Consultation Response from KC, Conservation & Design**2023/92634 St Marys Rc Church, Upton Street, Carlinghow, Batley, WF17 8PH****Listed Building Consent for Demolition of buildings and erection of residential development
(Listed Building within a Conservation Area)****Date Responded: 12.4.2024****Responding Officer: Sue Brooks****Responding Ref: BHS 4/15**

drawing
Proposed Typical Dwelling Floor Plans

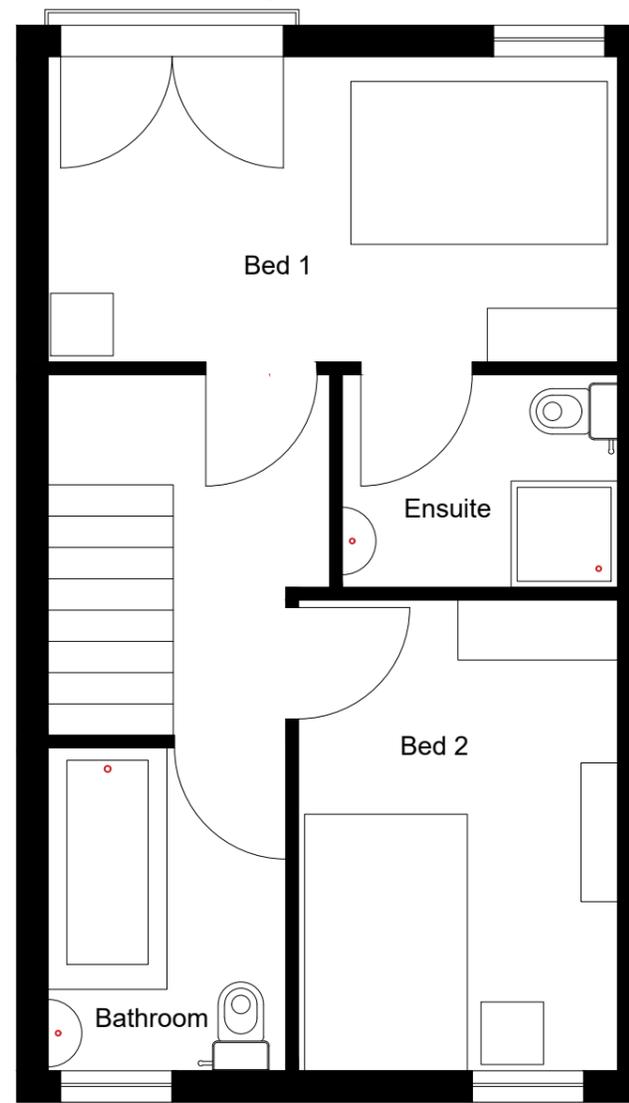
- Design – we would recommend that the design is revisited in line with the requirements of the policies above. References could be taken from the existing buildings on the site, with the use of natural stone and blue slate, and perhaps with architectural detailing reminiscent of the school extension, including small dormers or gables. The design of the Upton Street elevations appear secondary and we would recommend that the nunnery is retained, with the potential for new dwellings adjacent to this in place on the former houses on the site.

- External masonry - the proposed buff brick with brick detailing is not characteristic of the conservation area, and we would recommend natural coursed stone is specified with traditional detailing.

- Timber doors – these are acceptable subject to design – this can be a condition.
- Roofs - artificial grey slates are specified in the application form, whereas the design document refers to a blue tinted roof covering and a copper finish. Blue slate would be more characteristic of the site and wider conservation area and existing buildings on the site.

- UPVC windows - The Design document states that the window types aim to establish a sense of visual continuity, ensuring that the new residences harmoniously blend with the architectural heritage of the area, and it references design details and elements that are not shown on the proposed drawings or specified in the application form. We do not consider the proposed window design to respect the local context and would recommend that timber windows are specified in a traditional design, taking references from local characteristics.

- Bin stores and parking spaces to the front of the properties – these should be located to the rear so that the more attractive elevations face the cemetery. We would suggest that coursed natural stone from the demolition (if justified) is used for low boundary walls on the south and west boundaries to reflect the local character.
- The Climate Change Statement specifies solar panels on the roofs of all properties. No details have been submitted and the south pitches are highly prominent, facing the cemetery, and therefore this should be omitted.
